Consultee Comments for Planning Application 22/00465/FUL

Application Number: 22/00465/FUL

Address: Land Between 67 and 73 Park Square West Jaywick Clacton On Sea Essex CO15 2NT

On Behalf Of: Tree & Landscape Officer

drawing title
 Site Plan & Street Elevation

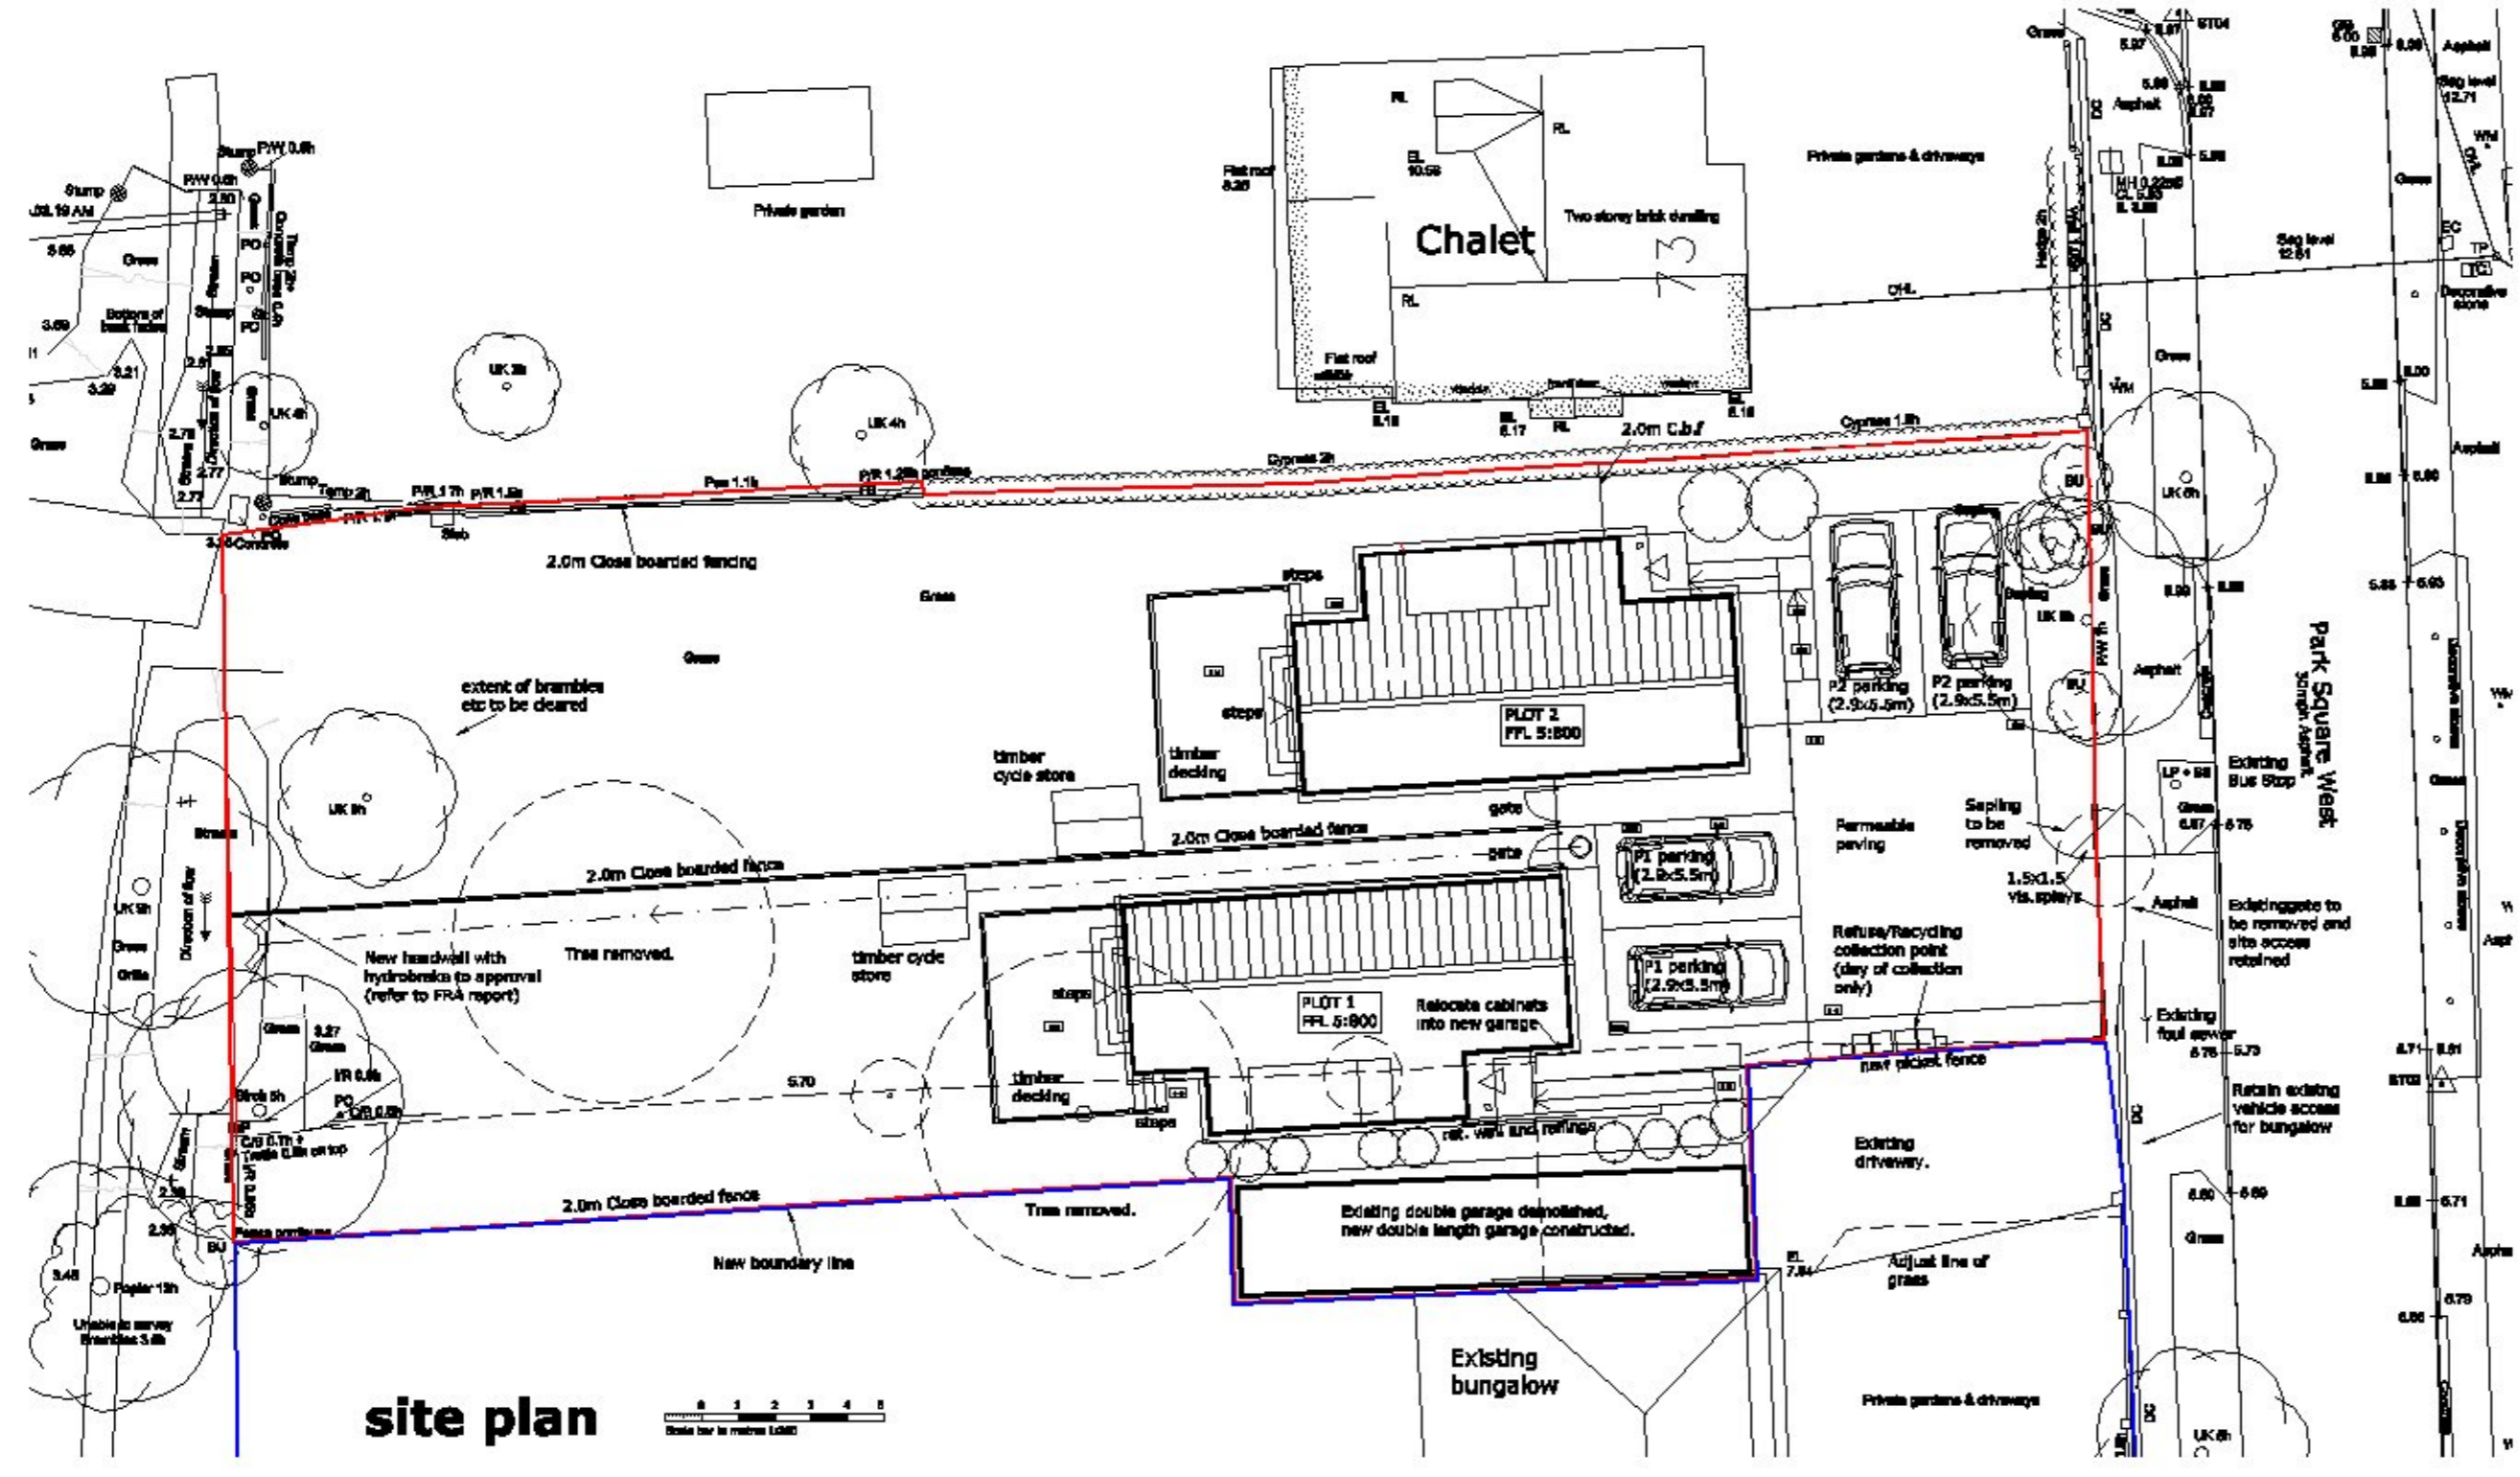
On the boundary with the back edge of the adjacent footway there are several small trees comprising Oak, Hawthorn, Elder and Lilac. Whilst these trees are pleasant features in their setting their condition and amenity value are such that they do not warrant retention or meet the criteria under which they merit protection by means of a tree preservation order.

There is a small Malus situated in the grass verge to the front of the application site which will not be adversely affected by the proposed development of the land.

Immediately to the rear of the existing garage forming part of the residential curtilage of 67 Park Square West there is an early mature Weeping Willow that can be clearly seen from the highway. Consequently the tree has moderate amenity value.

Close inspection of the tree reveals an included branch union on the main stem where it divides into two. The union is defective and there is clear movement where the branches are weakly attached.

As the tree contains a significant structural defect it is not viable in the long term and does not merit retention or formal legal protection by means of a tree preservation order.
